Mill Cottage, Clymping Mill

Addendum to
Planning & Heritage Statements

Mill Cottage - Addendum to Planning & Heritage Statements in support of changes to previously approved applications CM/22/18/L and CM/6/19/HH

Ground Floor Plan : As Proposed
SCALE 1=50

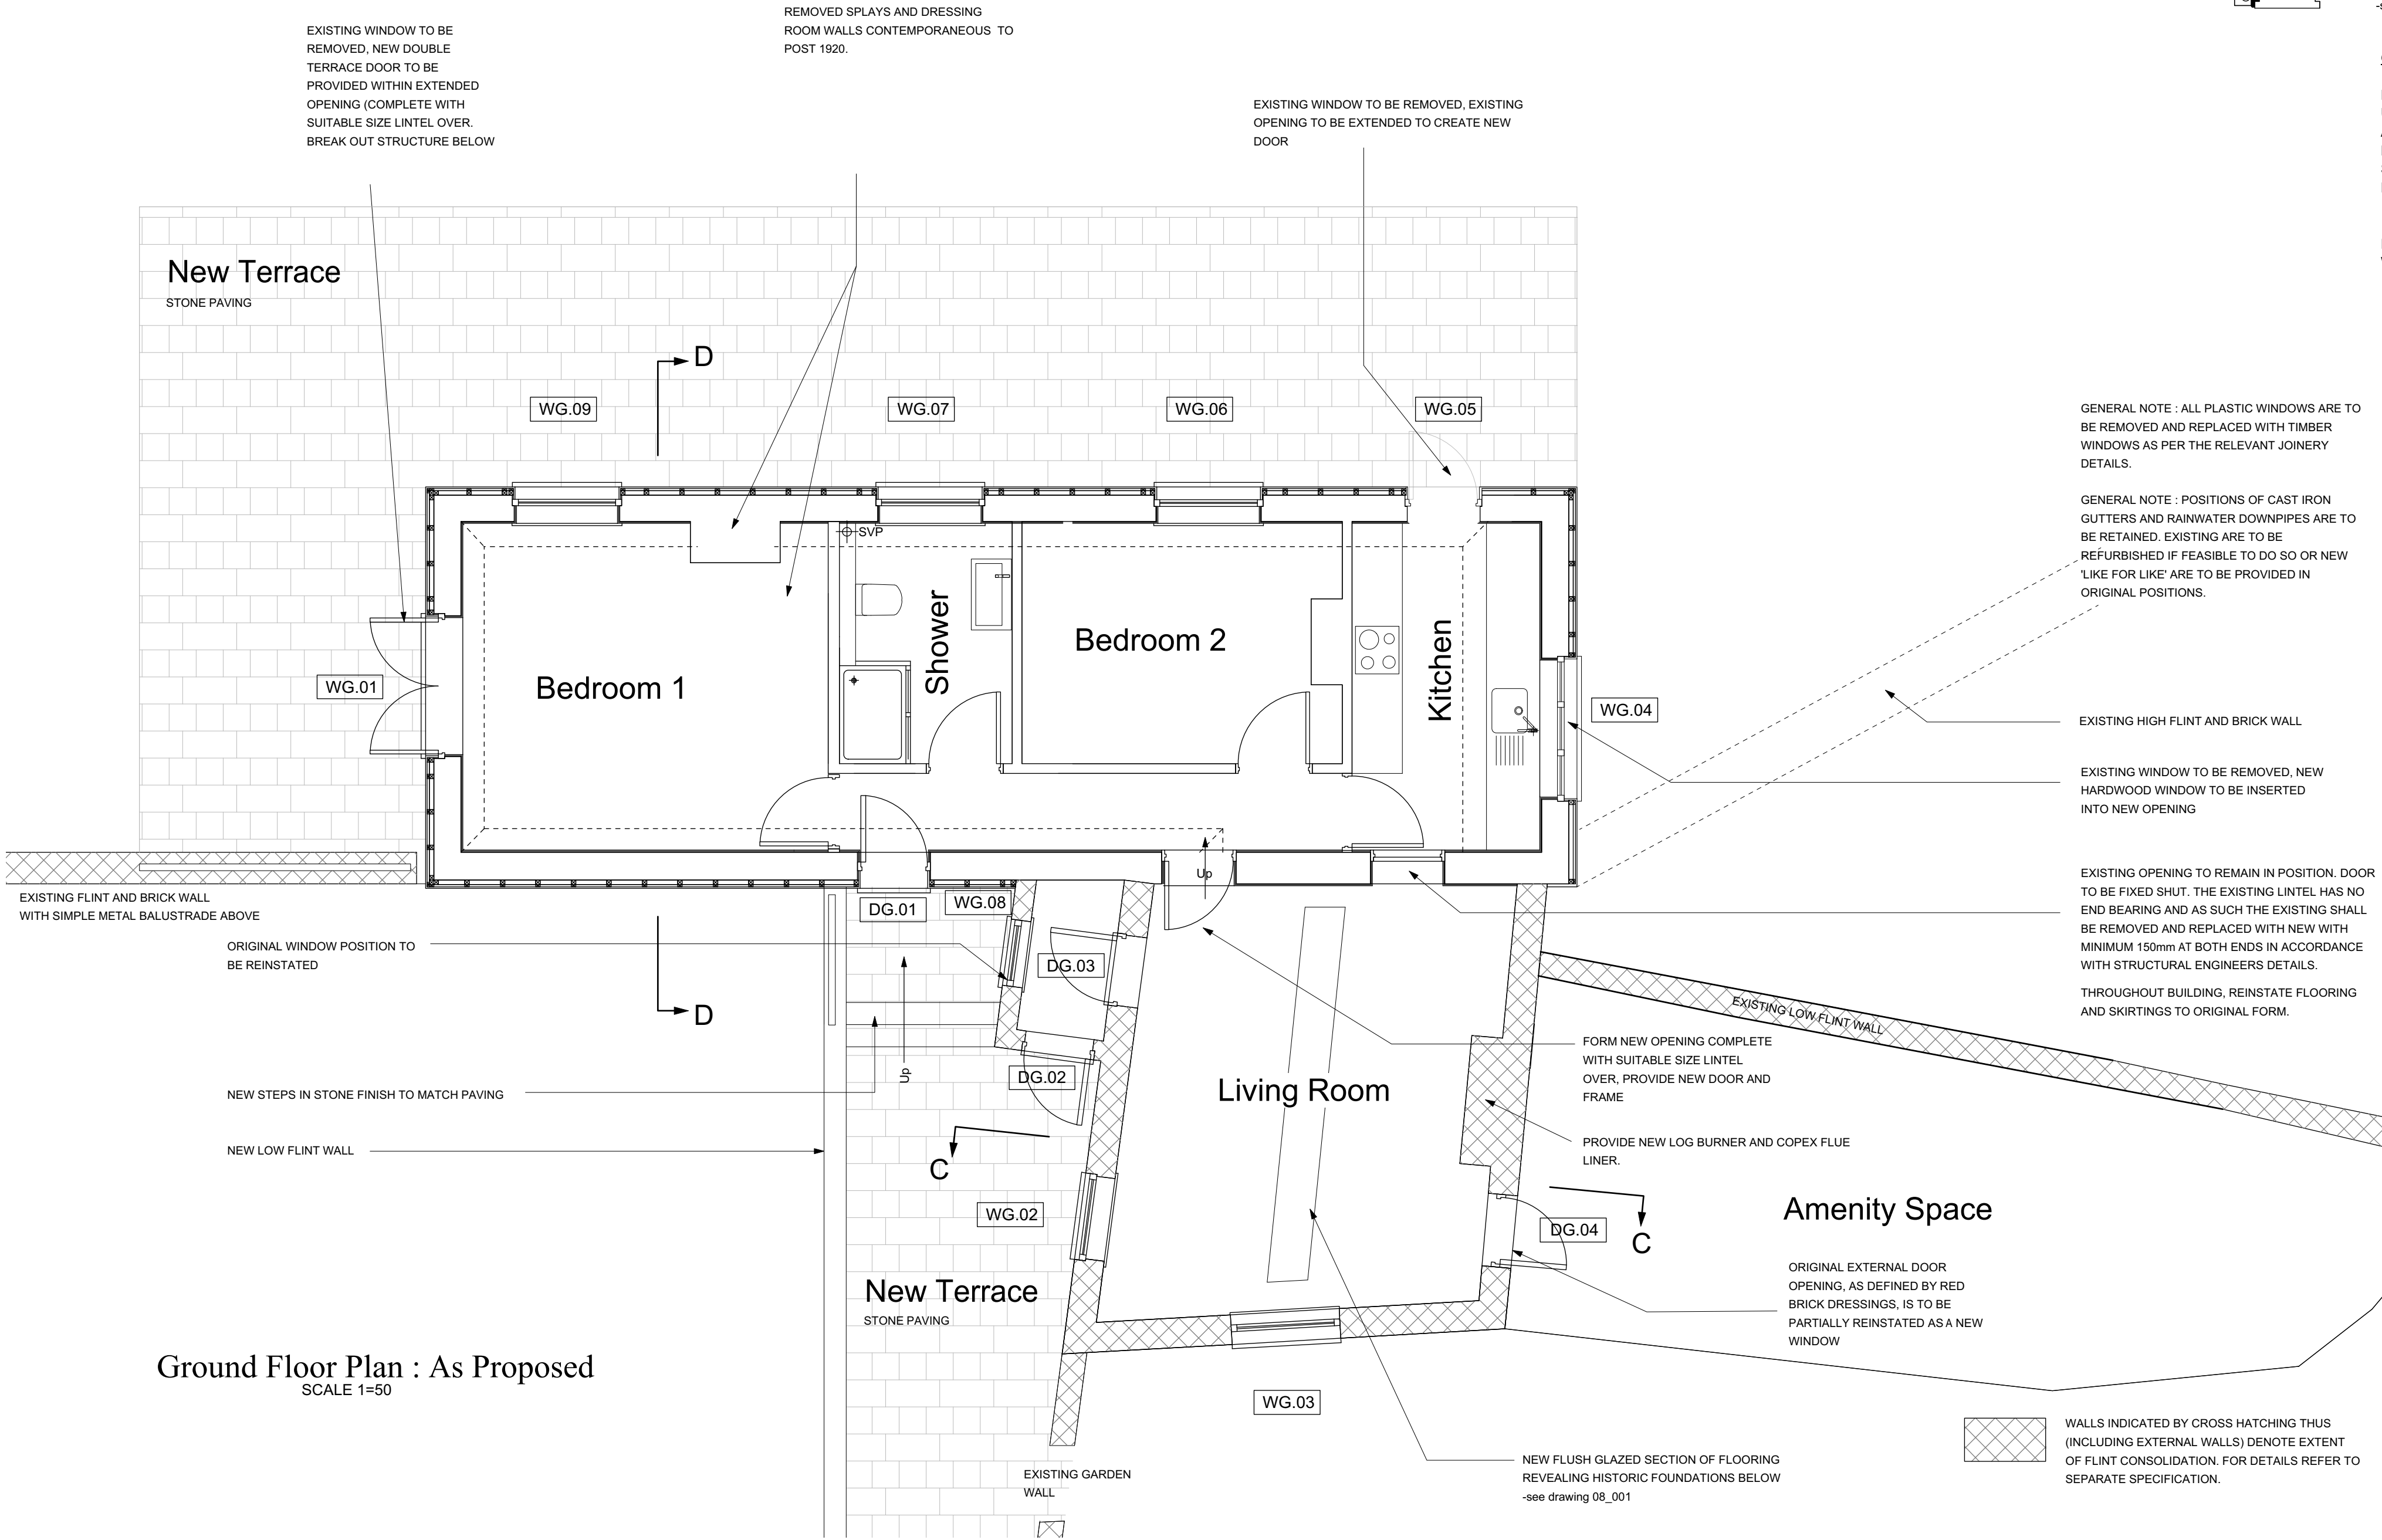
3) Minor internal layouts

The proposals show a minor amendment to the internal layout of rooms in the more modern eastern range with the removal of internal walls that were part of later alterations post 1920's

5) Amenity space

Set within the wider residential curtilage, the amended terraced area and entrance steps and change of material to stone paving are more in keeping than the previously proposed timber decking.
